16 May 2018

**RE: Narrabri Gas Project - Aboriginal Cultural Heritage Assessment - Expert Review by Peter Kuskie, South East Archaeology - Comment on Proponent's Response to Submissions**

The Aboriginal cultural heritage zoning scheme is illustrated in the sensitivity mapping in Figure 20-2.

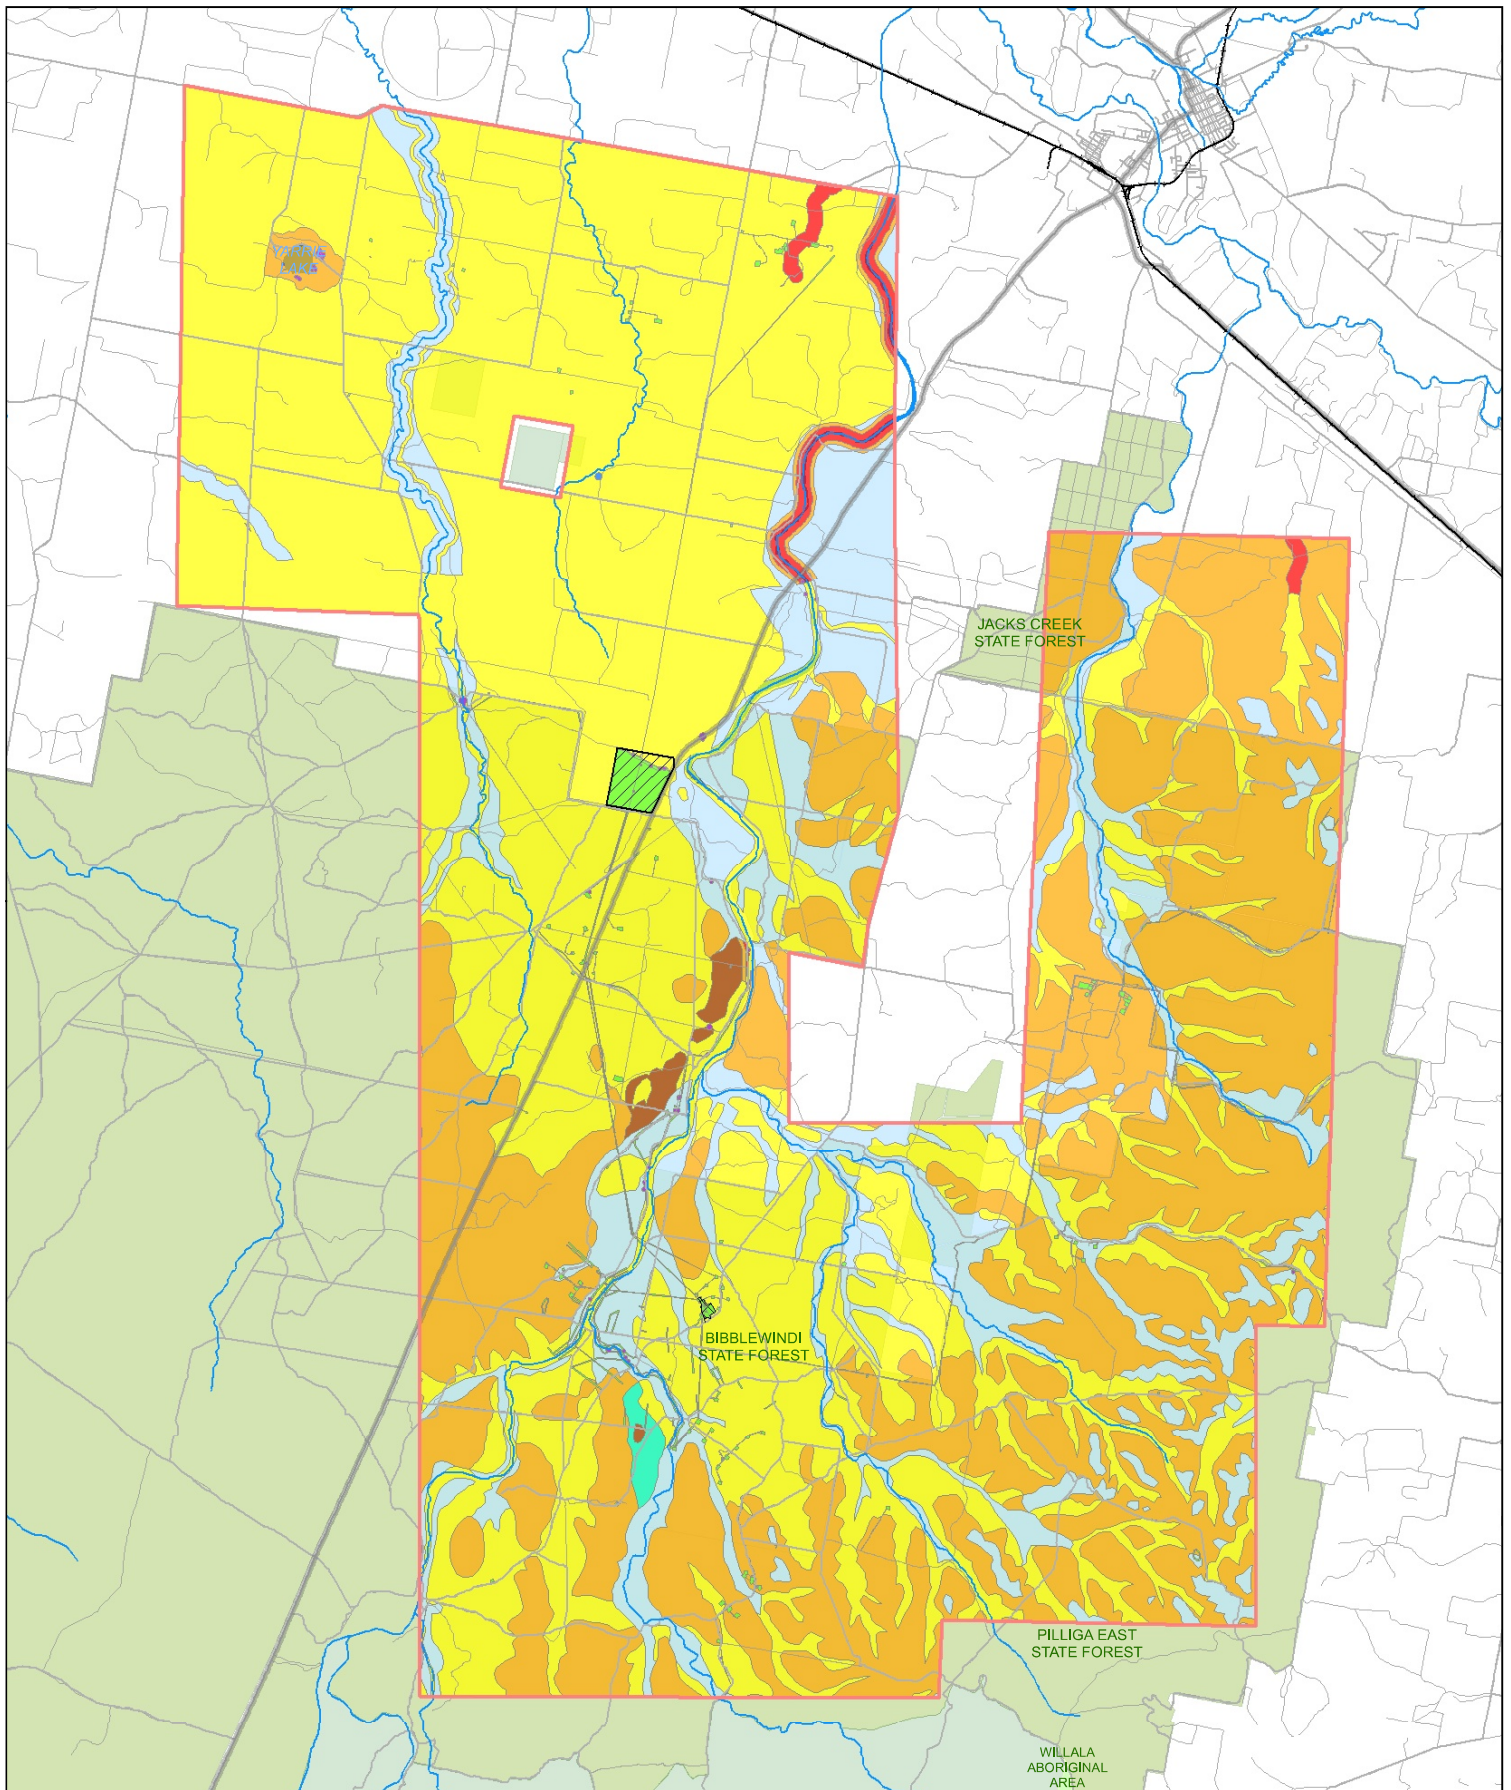
The proponent's attempt to step away from their fundamentally flawed de facto predictive modelling and 'cultural sensitivity mapping' and Cultural Heritage Zone Scheme that was presented in their own EIS defies belief.
